enquiries refer
Rod Mallam
in reply please quote
CM: 26/74665

28 August 2026

Re: Section 75W Modification Application for the Epiq Lennox Head Concept Approval Modification 11 (MP07_0026-Mod-11)

EPIQ LENNOX HEAD ILLUSTRATION C1 - CONCEPT PLAN

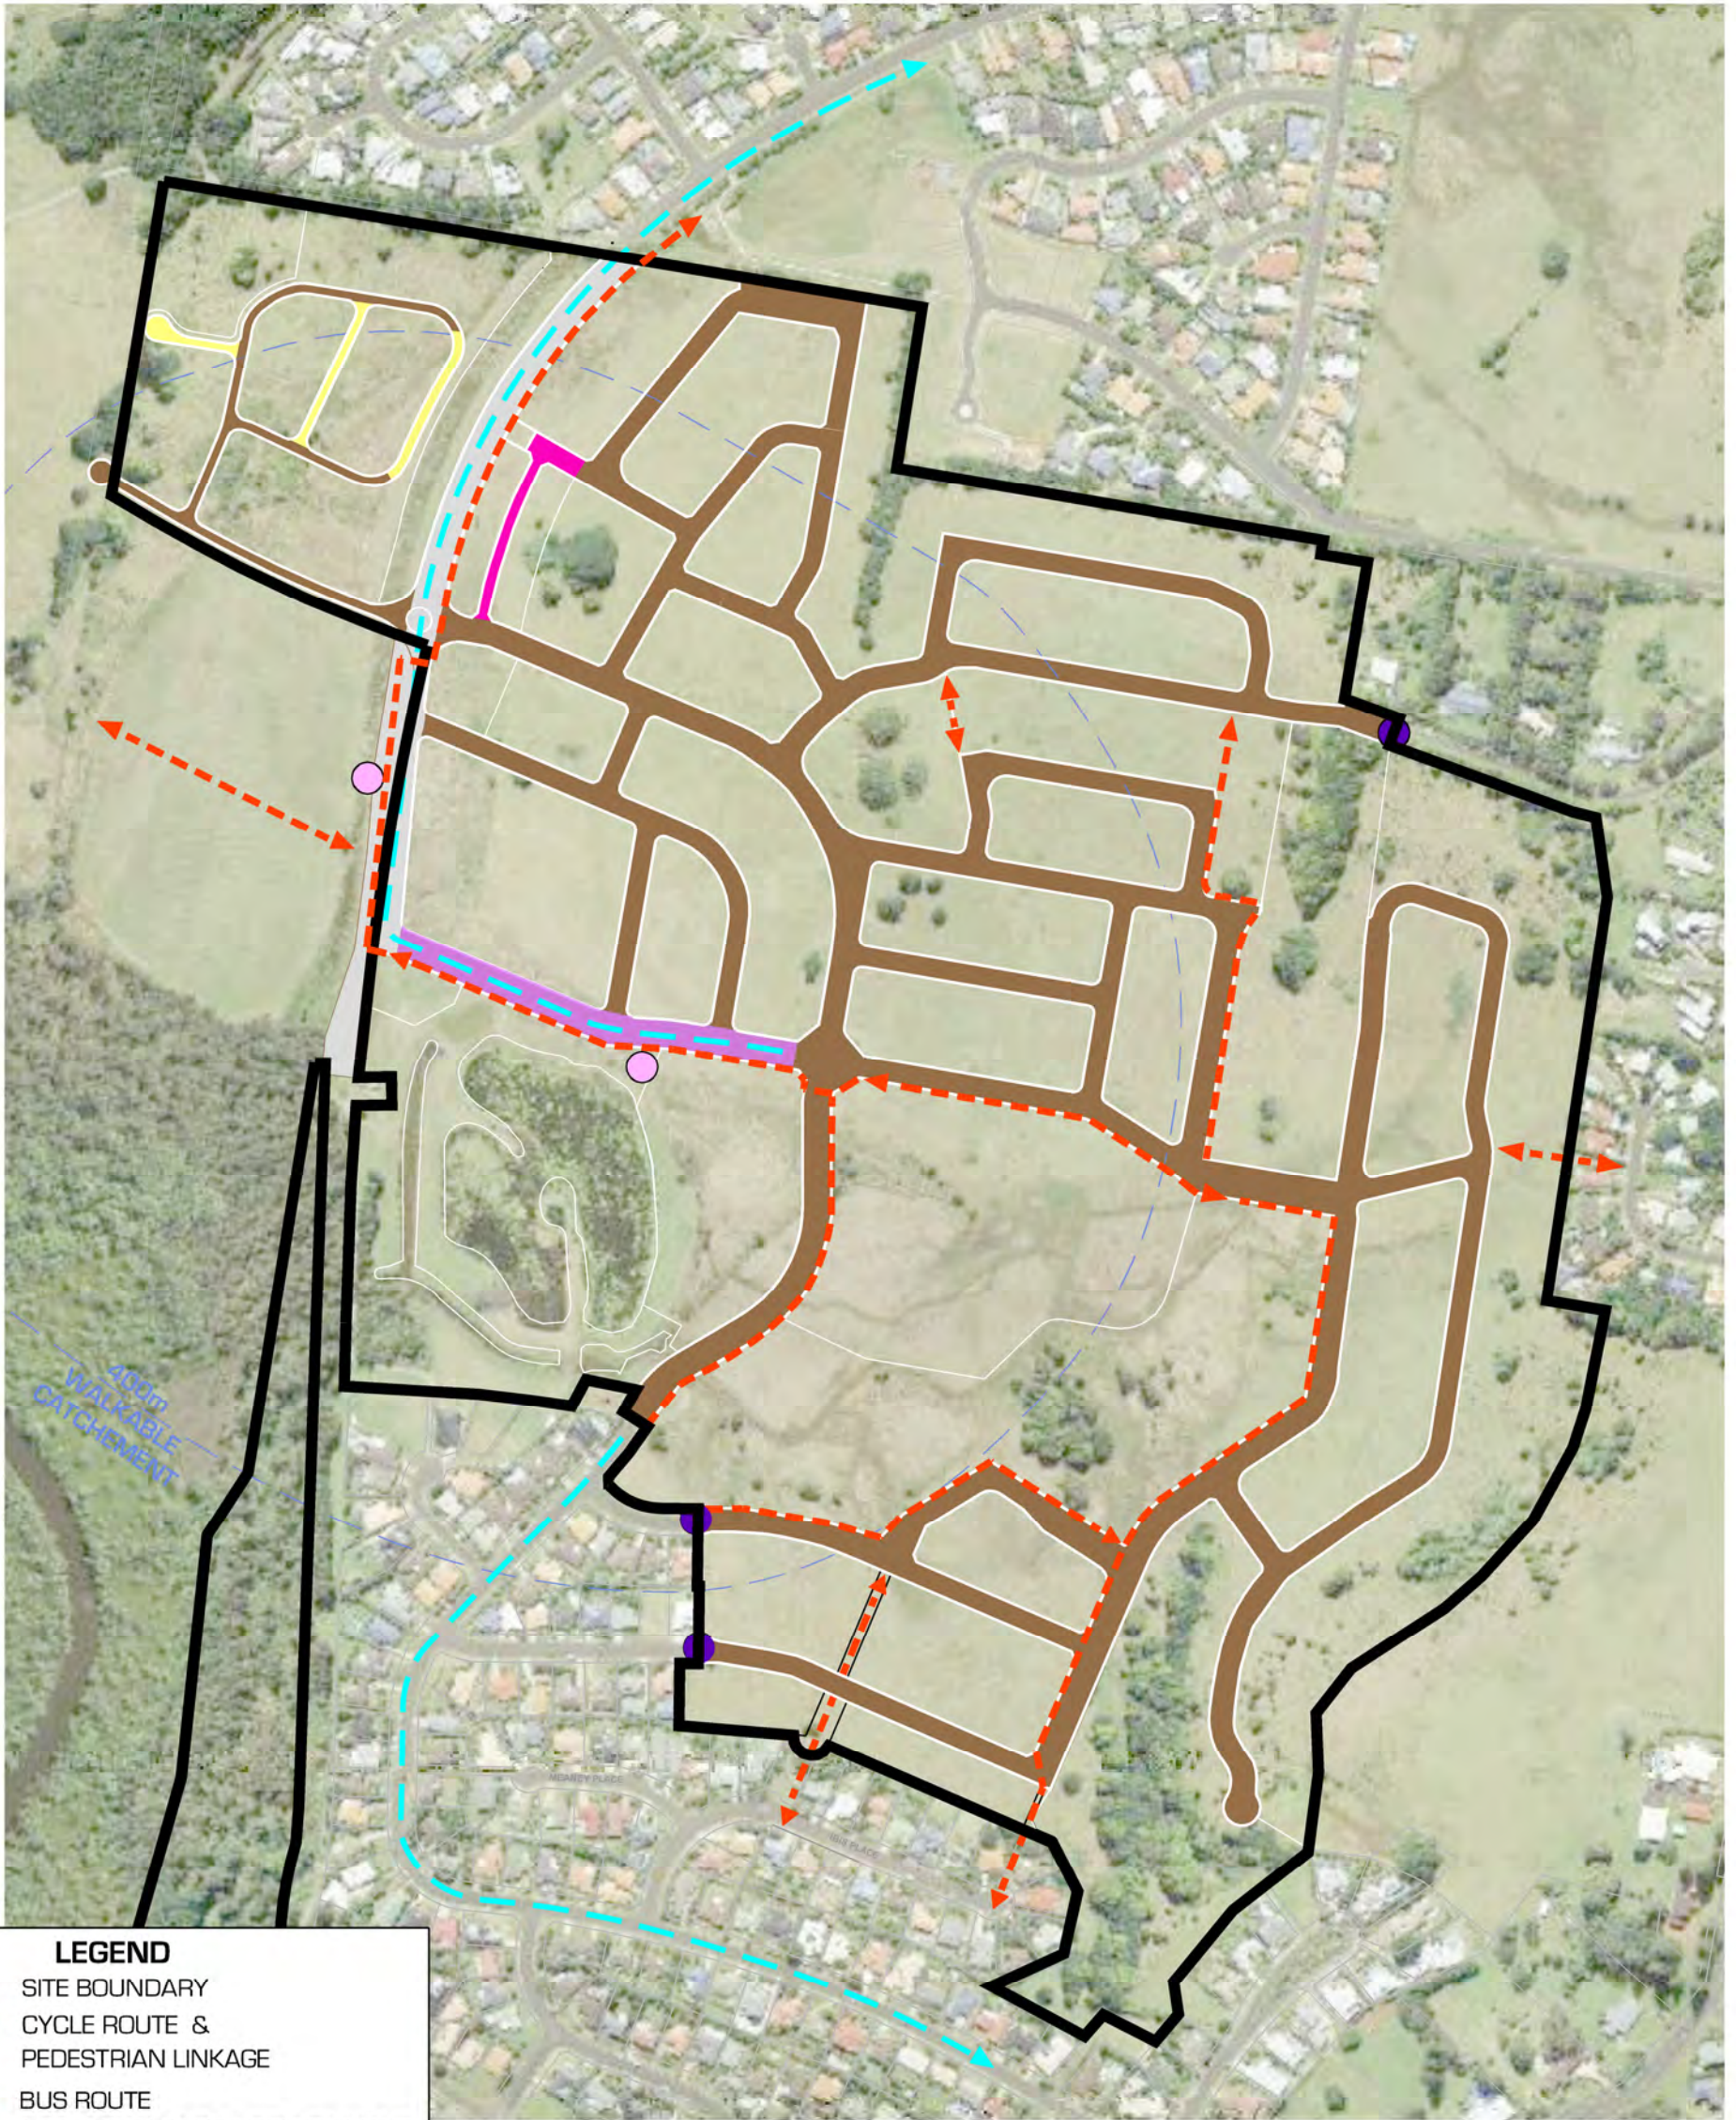
The colour scheme and legend notations on proposed modification plan - *Plan C1 (Rev H)* appears to be incorrect and needs to be rectified. In this regard:

- the **Red** is understood to be for Commercial / Storage Premises / Light Industry and is not shown in the correct colour on the plan;
- the noted that the light industry land use relates to Lot 60 only and not Lot 61. In this regard the red revision cloud/bubble on Plans C1 and C8 is to go around Lot 60 only; and
- the approved **Light Blue** Live / Work areas are not shown in the correct colour on the plan.

EPIQ LENNOX HEAD ILLUSTRATION C10 - SETBACK

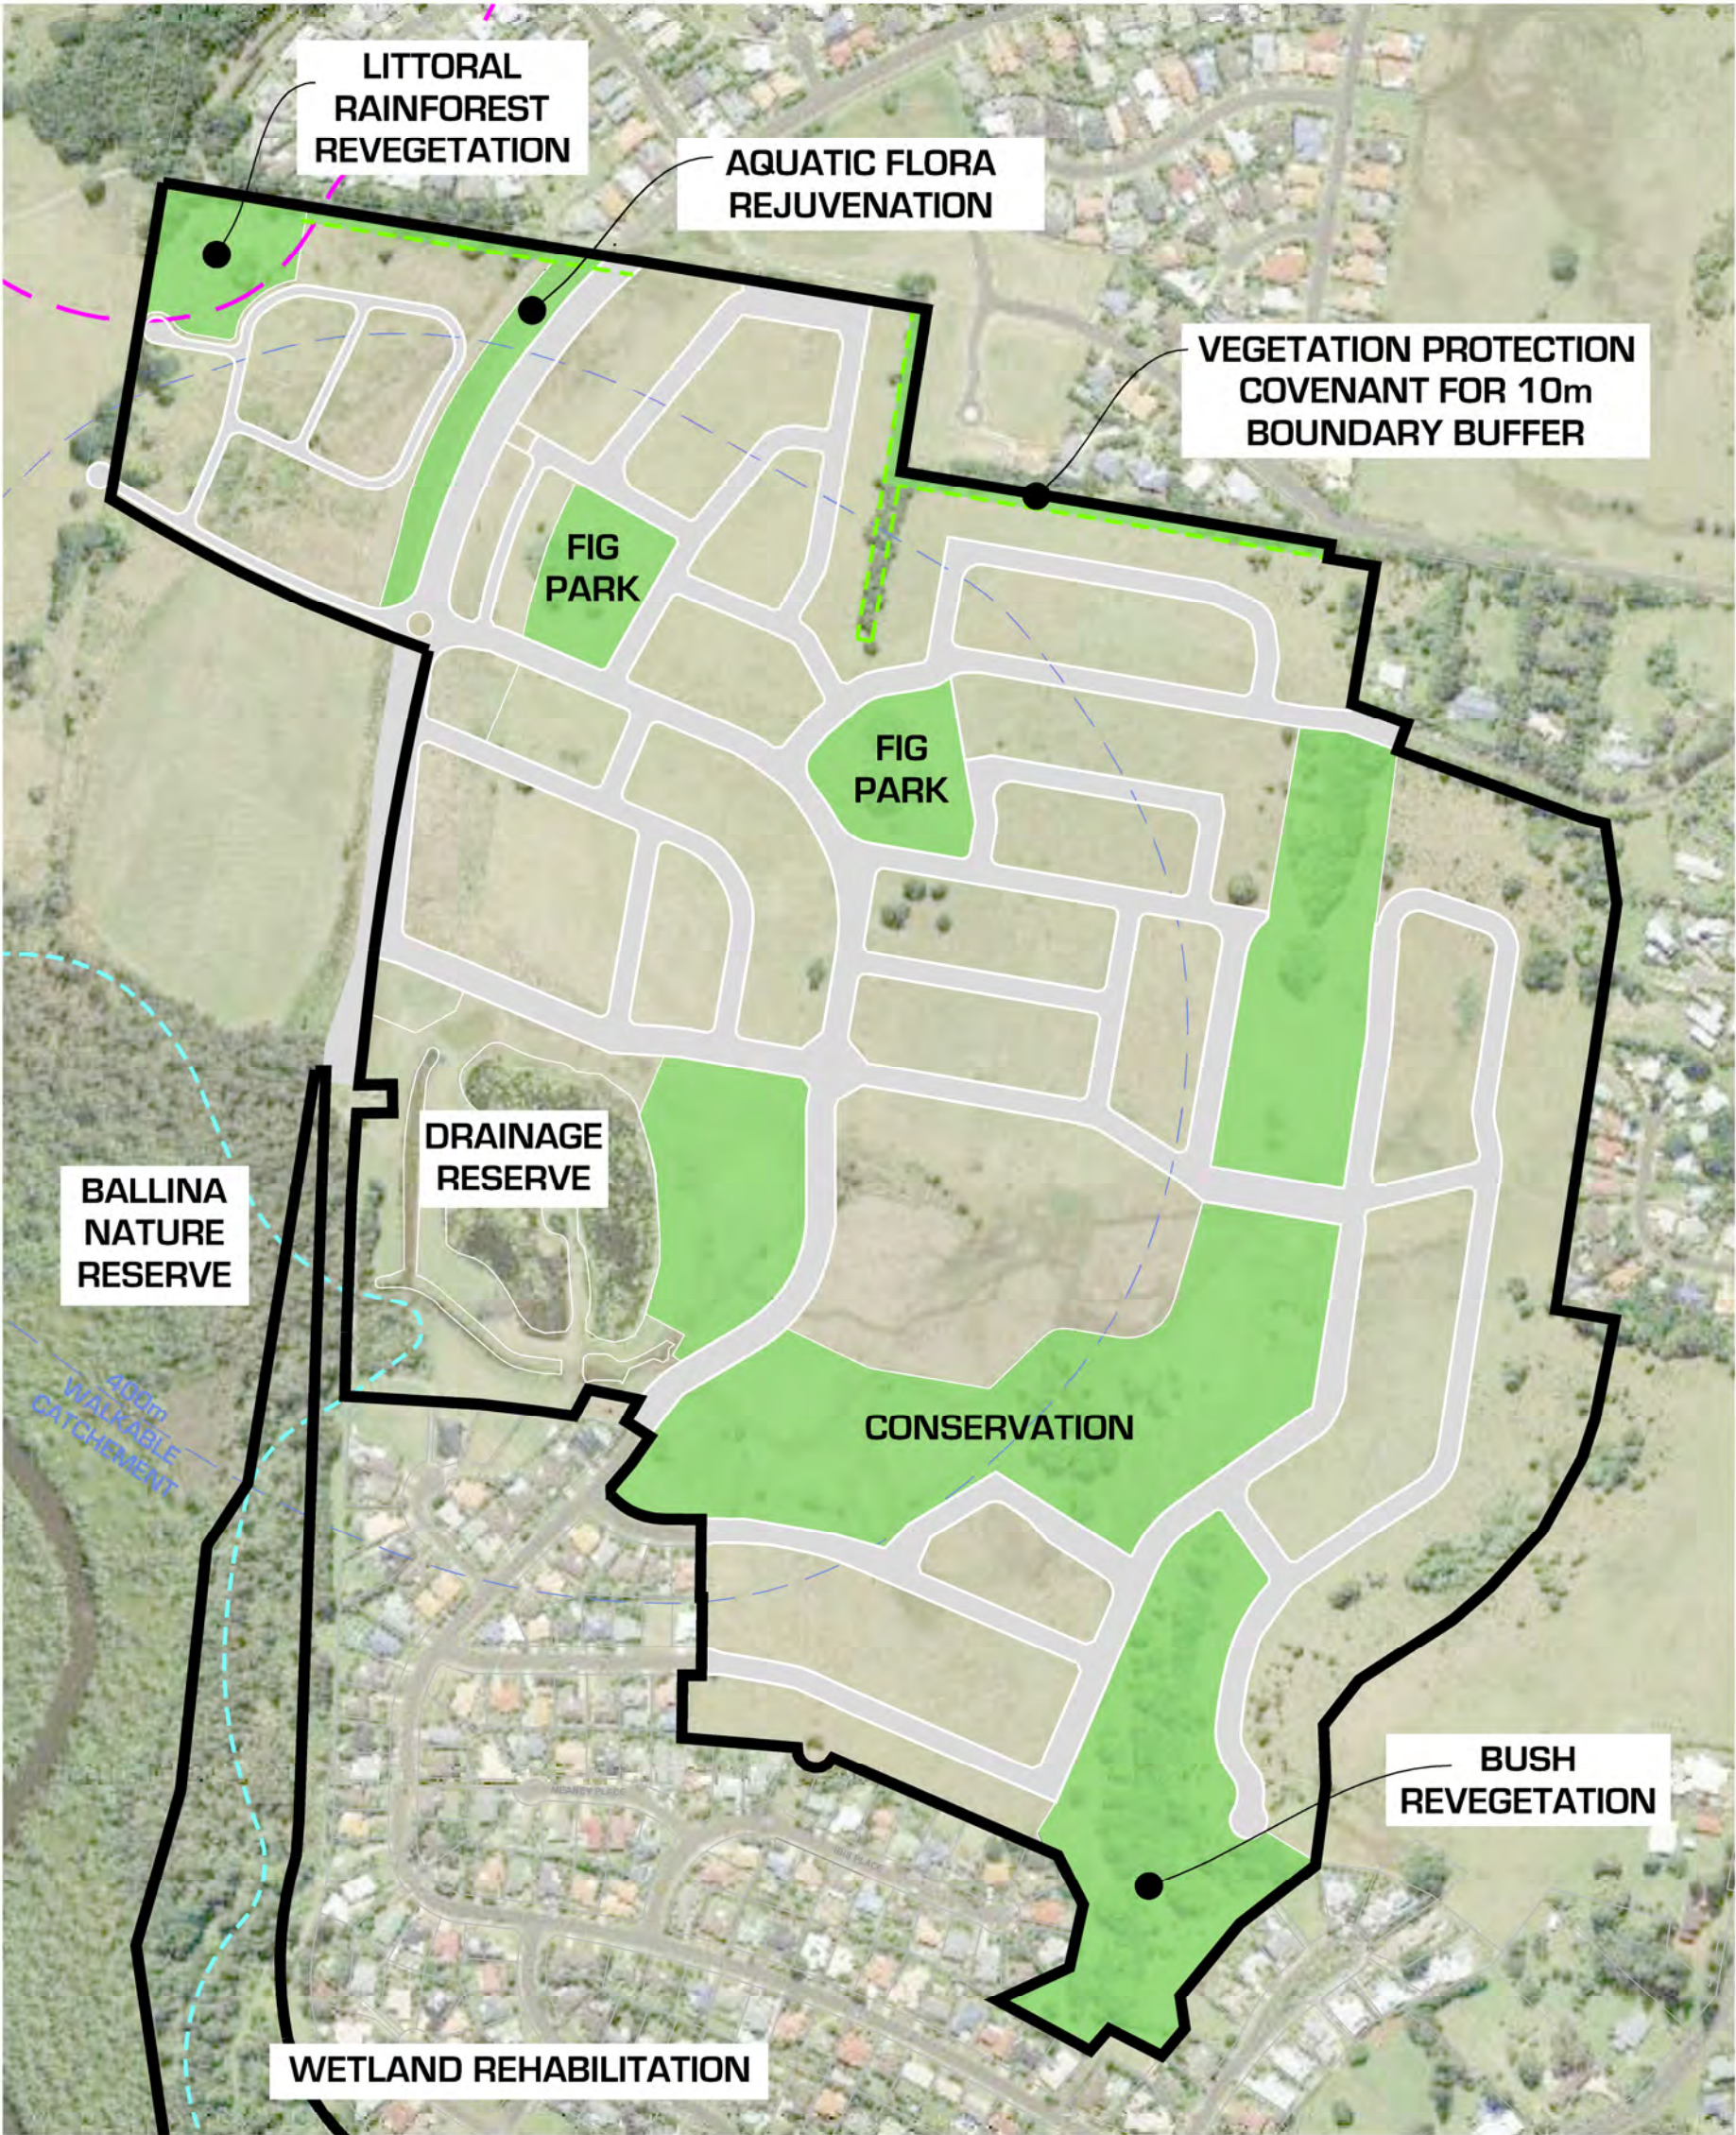
Front Setback to Street

The proposed minimum front setback of 1.5m to Salt Air Circuit is insufficient and is not supported by Council. It is recommended that this setback be increased to a minimum of 3m (or greater) to allow for appropriate landscaping between the building(s) and front property boundary and to minimise impact on the streetscape. As Lot 60 is a corner allotment, it is also recommended that this 3m (or greater) setback be extended around to the northeastern boundary of the site fronting Starboard Crescent.

When considering the above, please note that the front setback requirement for industrial development in Ballina Shire is 6m, however the surrounding live / work areas appear to have a 1.5m front setback requirement. Increasing the front setback to at least 3m would strike a reasonable balance between typical light industrial development within the shire and the surrounding live / work areas.

Rear Setback to Drainage Reserve / Public Footpath

The eastern side of the site adjoins an existing draining reserve / public footpath and is visible from Hutley Drive and the existing residential dwellings further to the east. Given the visibility of this part of the site from the public domain and surrounding residences, it is recommended that a minimum 1m setback be applied to the eastern boundary to allow for landscaping between the building(s) and the boundary / public domain.

In view of the above, Plan C10 should be updated to reflect these increased setbacks.
